**RE: Mt Arthur Mining Complex Modification 1 - Extension of Mining (09\_0062)**

## **Mount Arthur Coal Modification 1**

## **COUNCIL SUBMISSION**

24 May 2013

Figure 20 Final Landform Drainage Plan

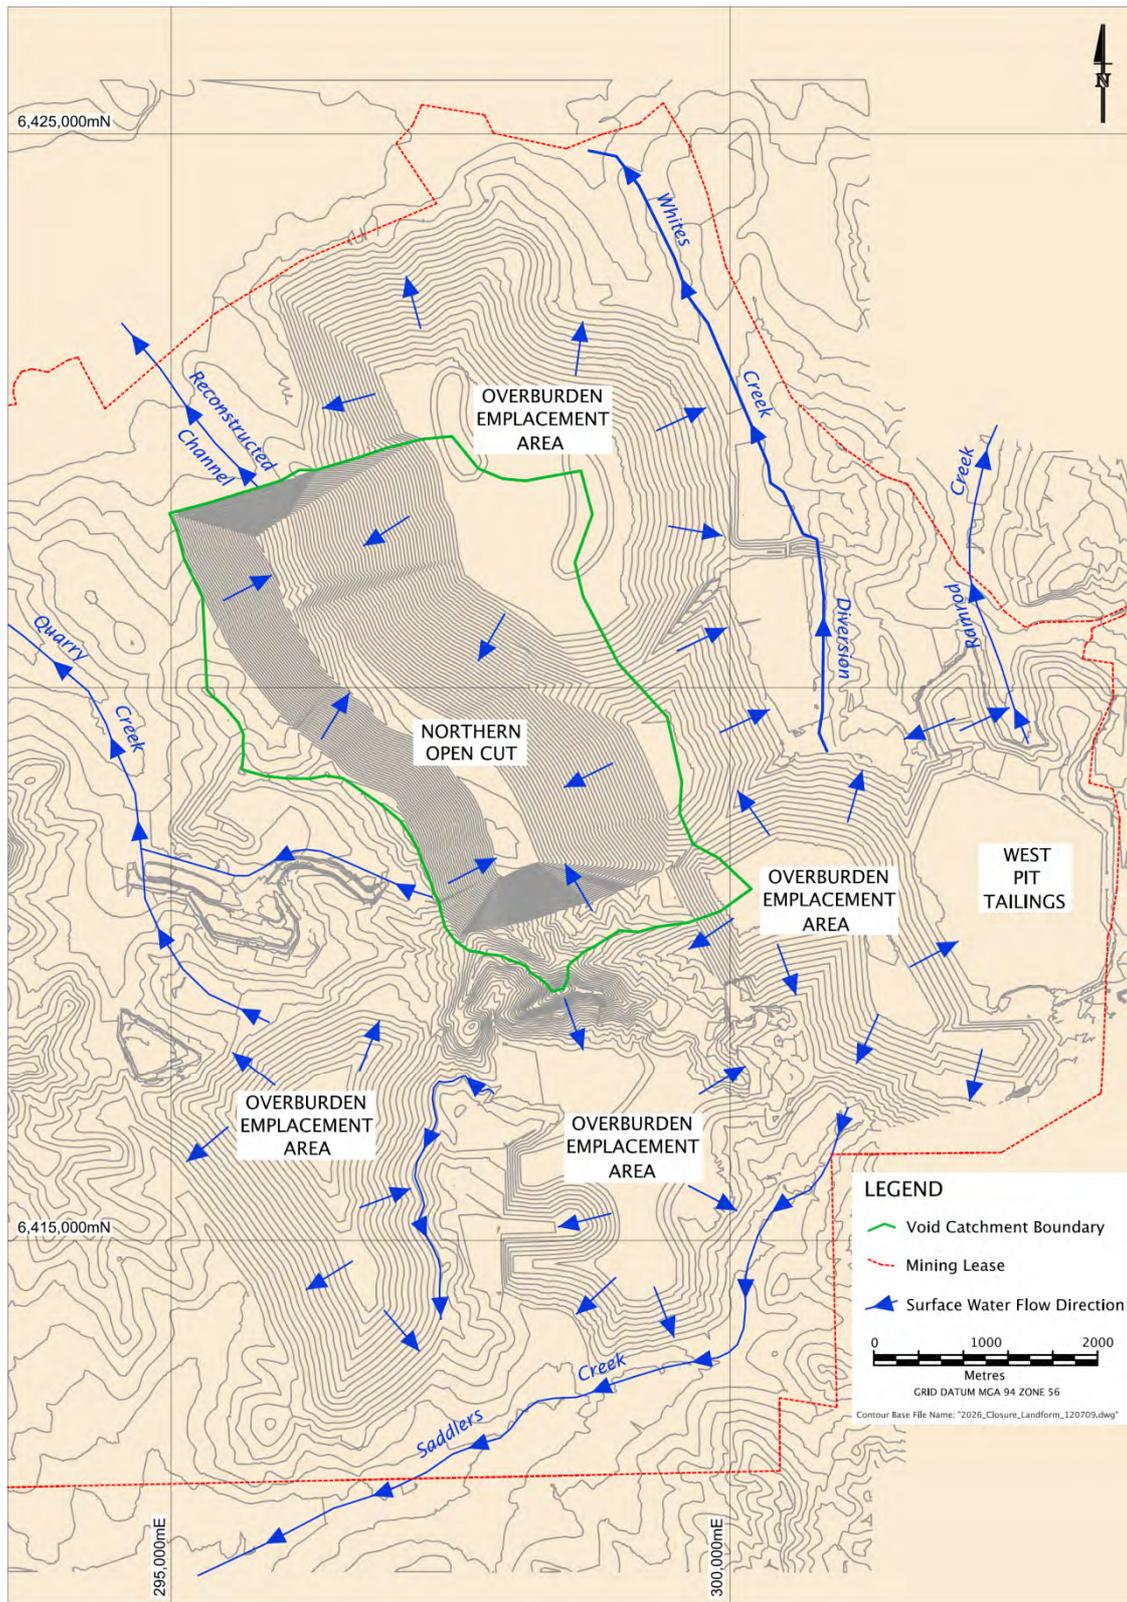
- 61. The Rehabilitation Strategy set out in the application has not provided a conceptual final land form and does not identify general slopes, grade and aspect, land form heights.
